From: Lauren Willard [REDACTED]
Sent: 21 June 2021 09:16
To: Zoe Toppin <Zoe.Toppin@arun.gov.uk>
Cc: Lauren Willard [REDACTED] Daniel Vick <Daniel.Vick@arun.gov.uk>; Juan Baeza <Juan.Baeza@arun.gov.uk>
Subject: Re: EP/16/21/PL

Drawing Number: 1241.01.h

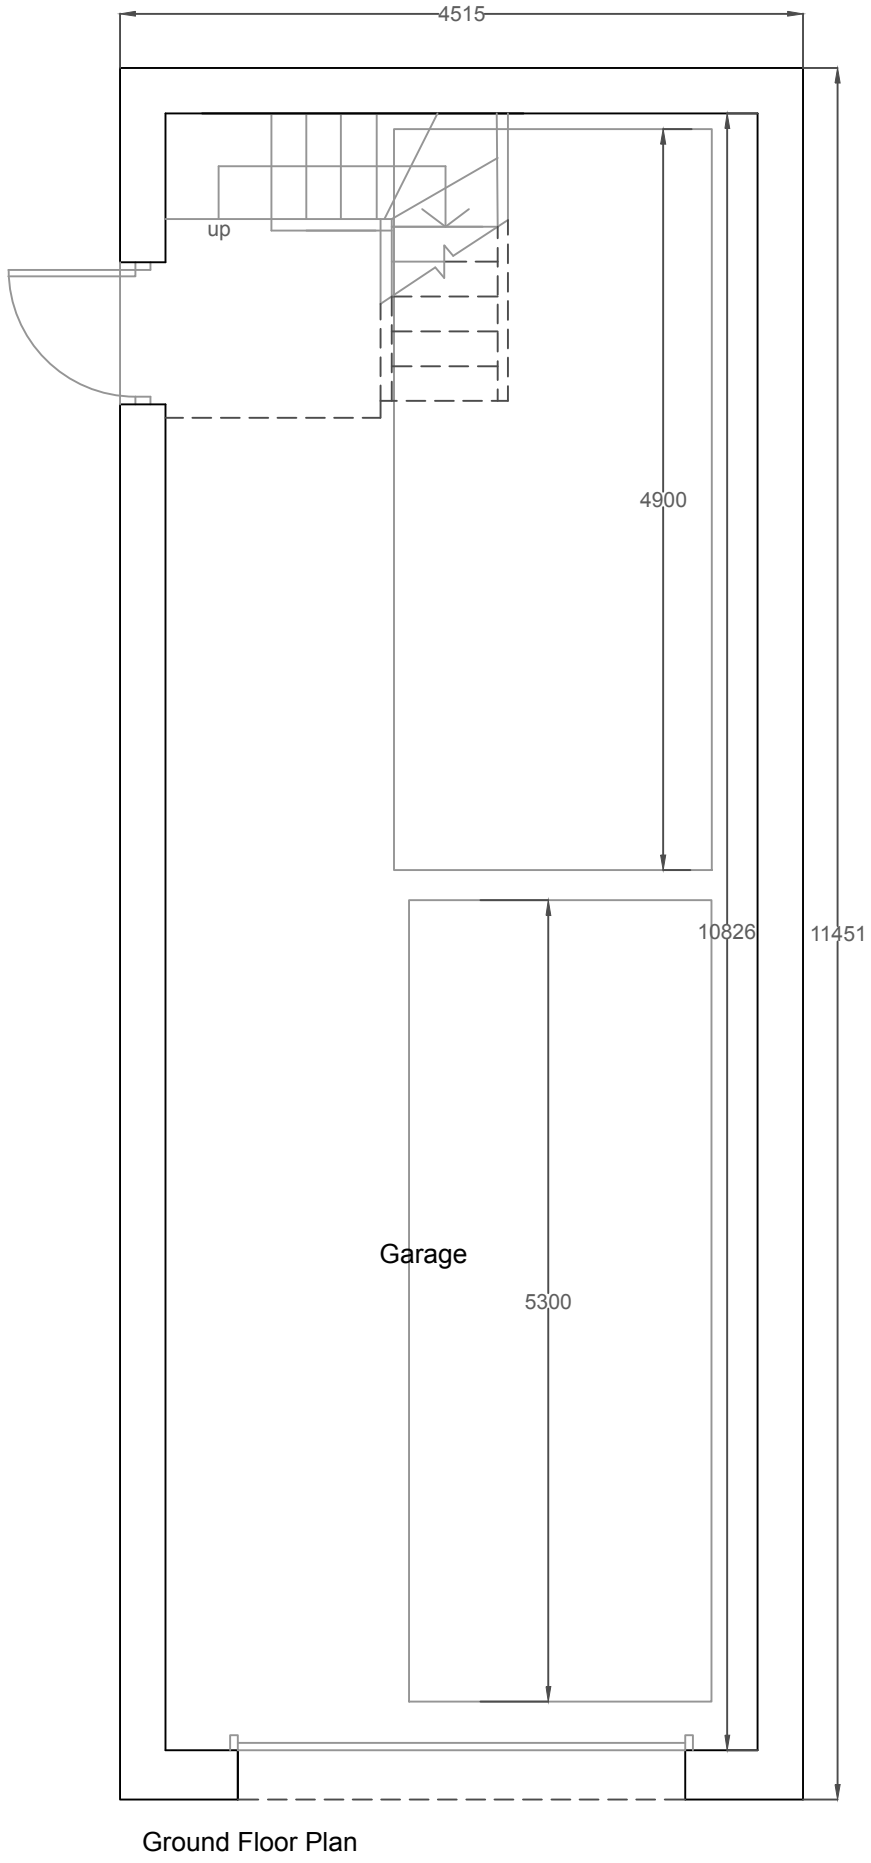
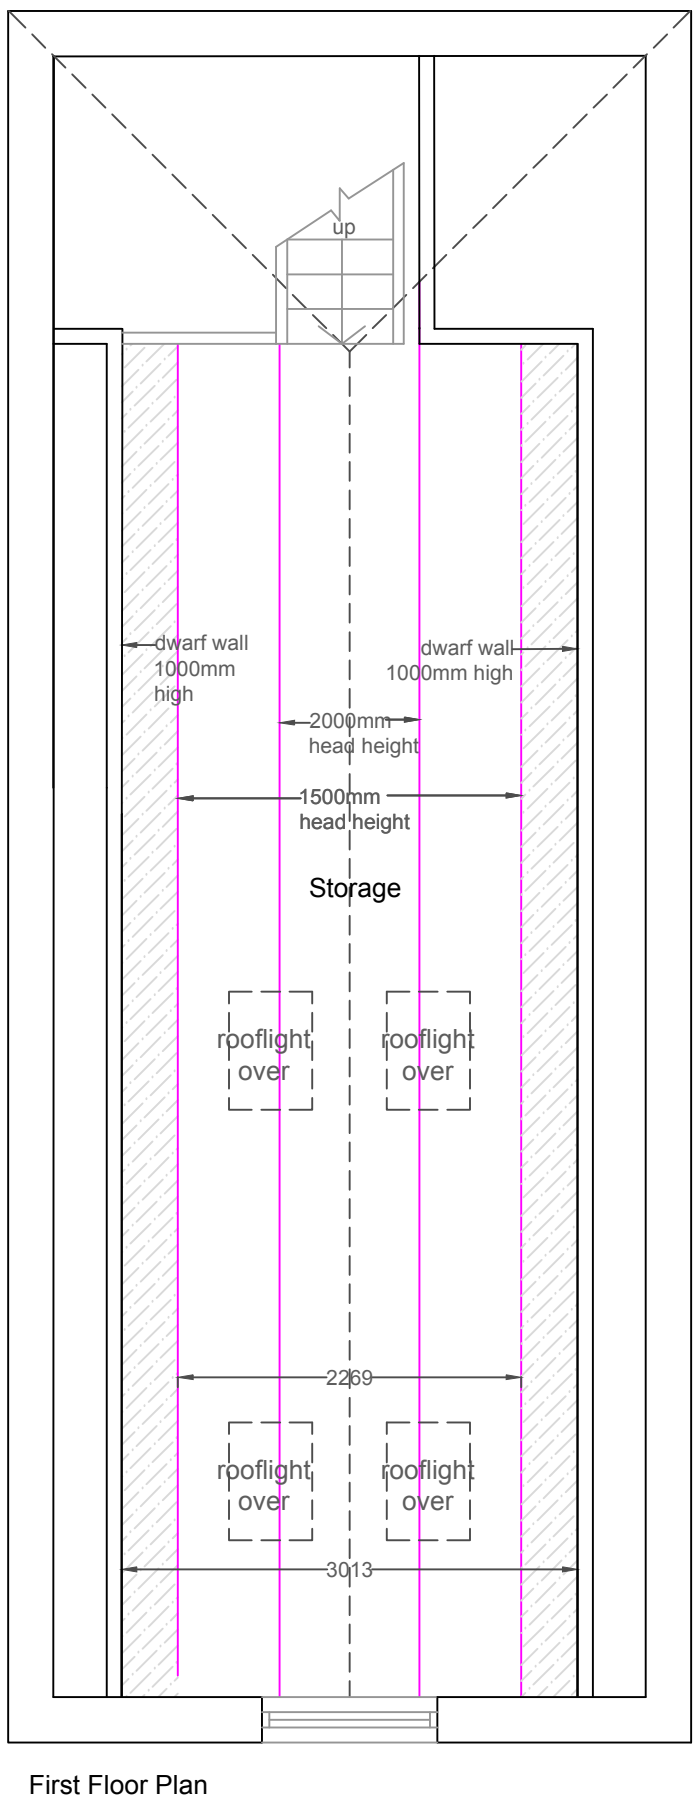
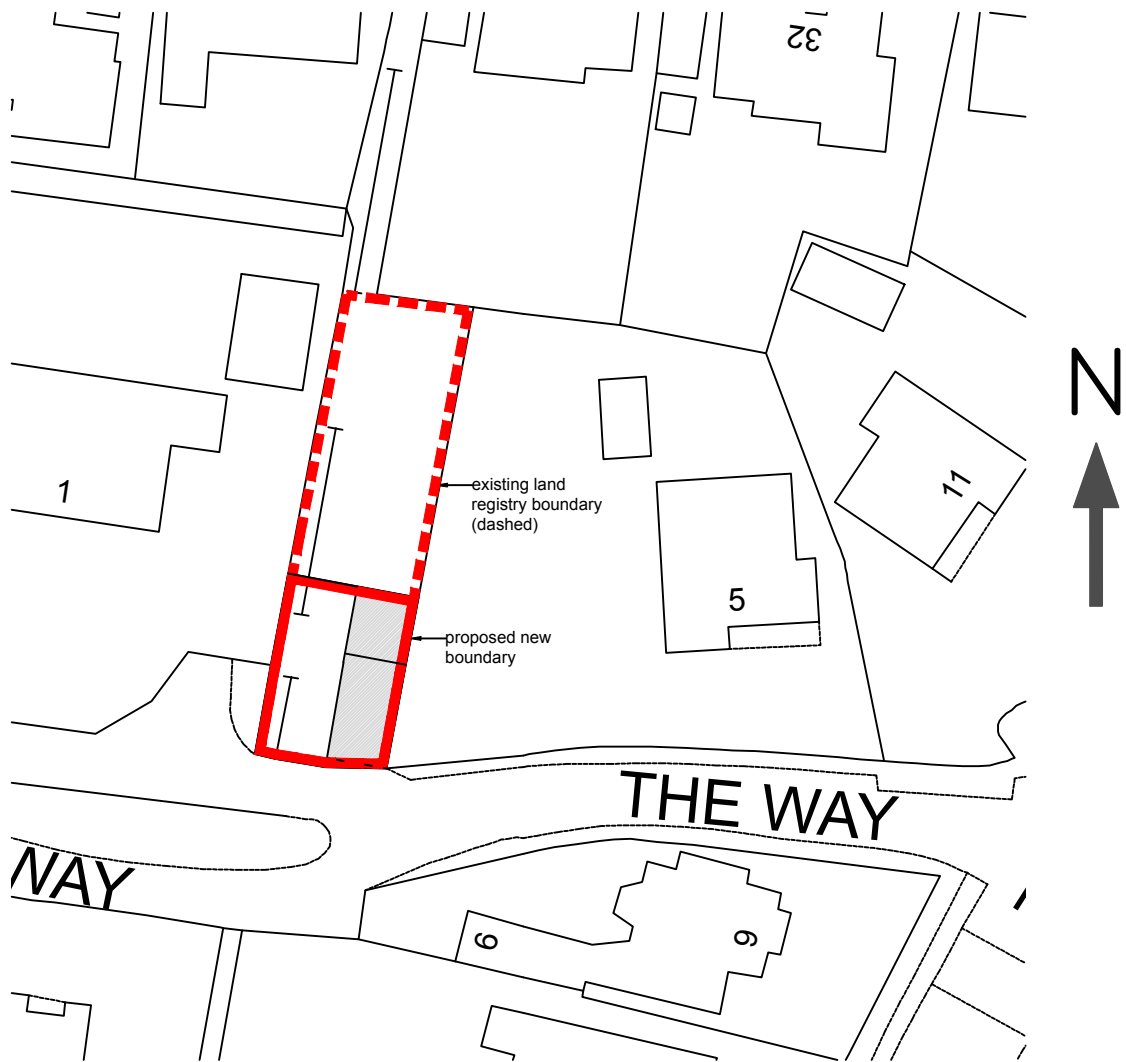
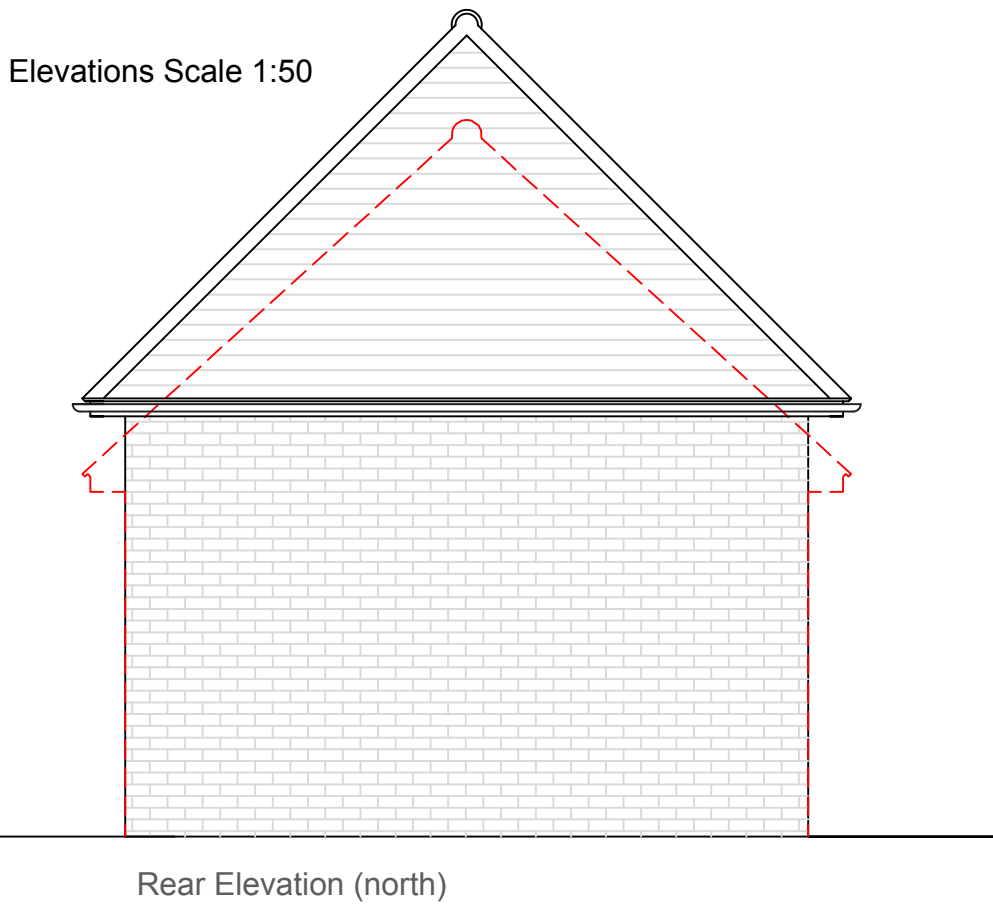
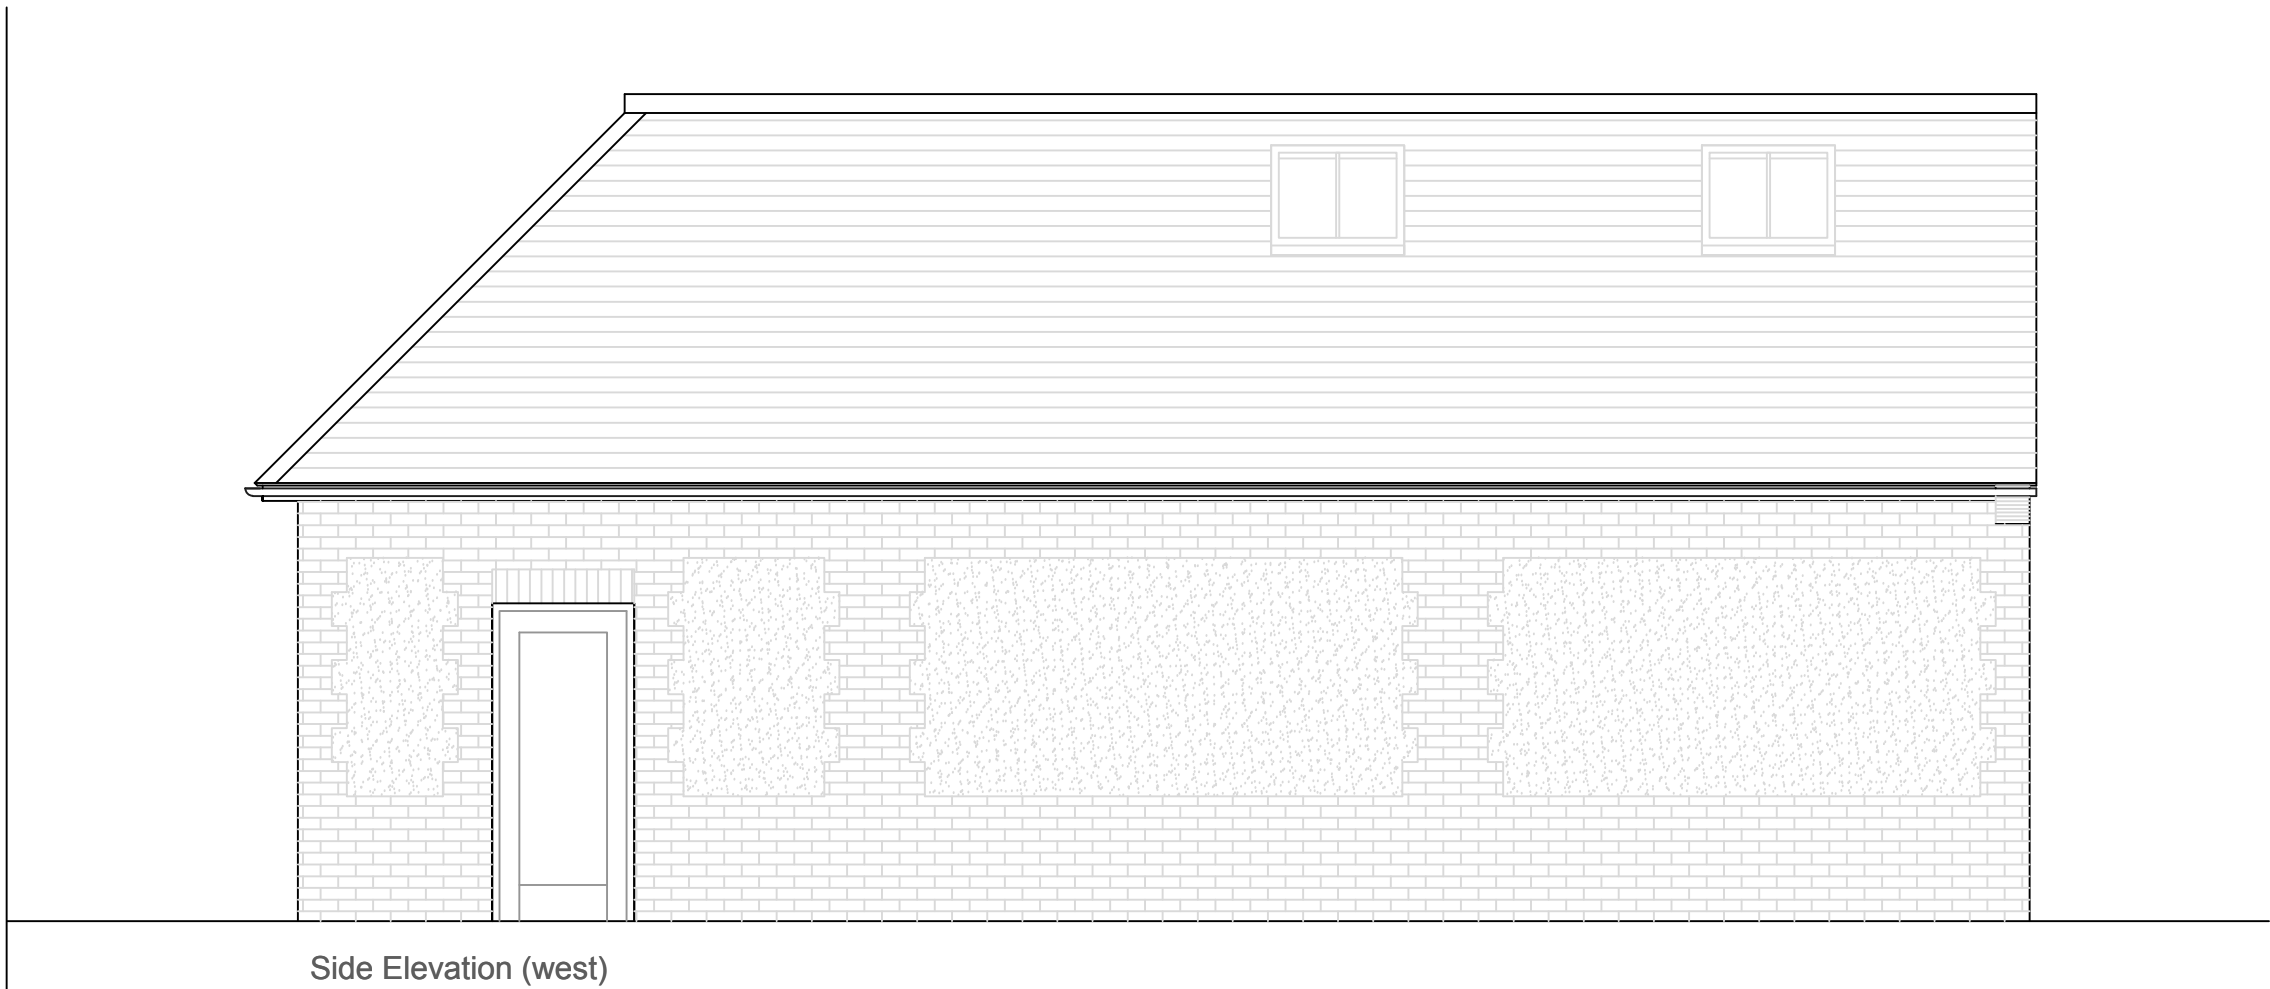
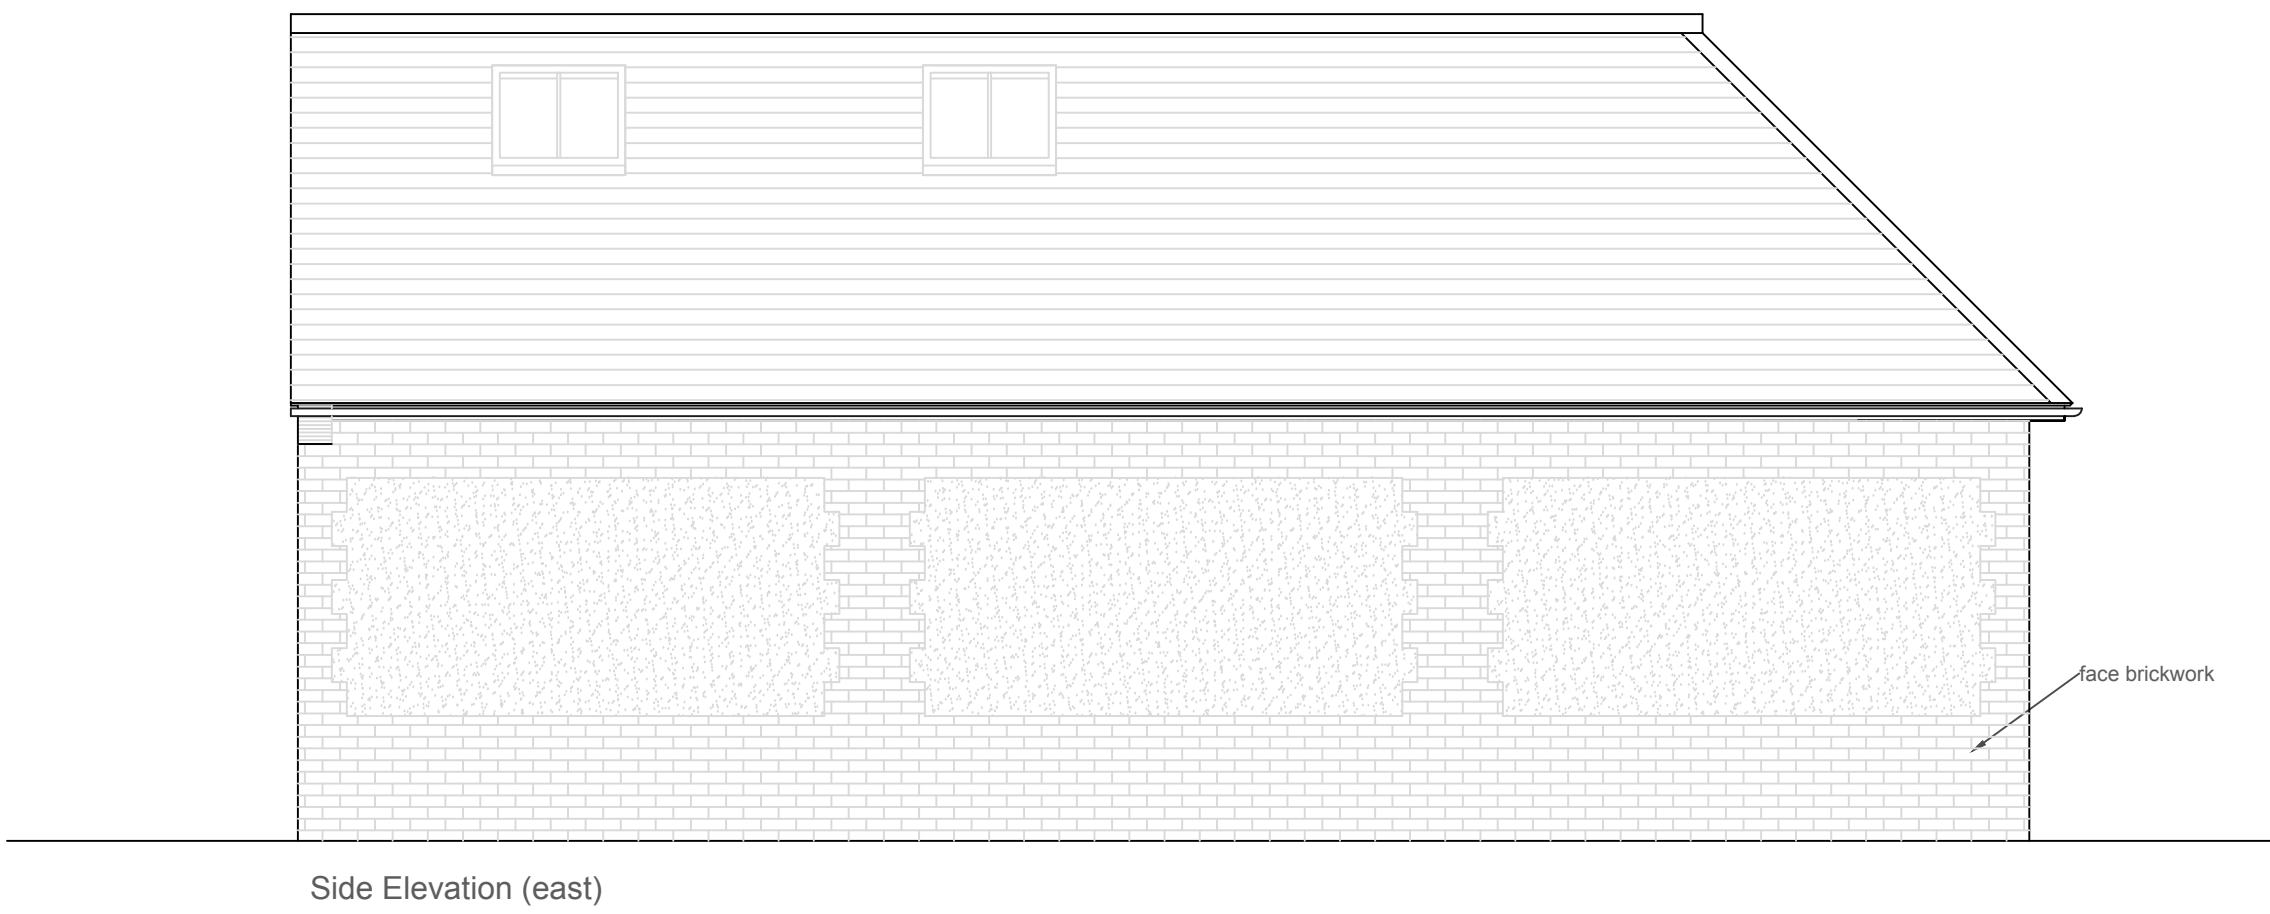
There has been a condition added to this application to show the three windows on the side (east) elevation of the garage will be permanently obscurely glazed and fixed shut up to a height of 1.7m from the finished floor level in order to protect the private amenity to the neighbours at the east. Please can you provide a plan to show this with a cross section from the ground to 1.7m to show the windows will be obscurely glazed and fixed shut up to a height of 1.7m.

There has also been concerns of why a dormer would be necessary for a garage if it is to be used as storage. As a result, it would be necessary to remove the dormer to the garage for this proposal. Please provide amended plans to show the dormer has been removed.

The three windows on west elevation should also be removed from the proposal as the garage will be used for storage there is no necessary need for windows, this will also create amenity issues.

1. An amended plan for the east elevation to show the cross section from the ground to 1.7m to show the windows will be obscurely glazed and fixed shut up to a height

I have removed the dormer and reduced the number of roof lights. I have also reduced the size of the roof lights and positioned them so the cill of the roof lights are 1.7m from finished floor level so there is no overlooking. I have included a section to demonstrate the position of the roof lights.

I have reverted to a hipped roof at the rear of the building which is as per the pre-application advice scheme. I have done this in order to accommodate the staircase and still provide space for the two cars in the garage.
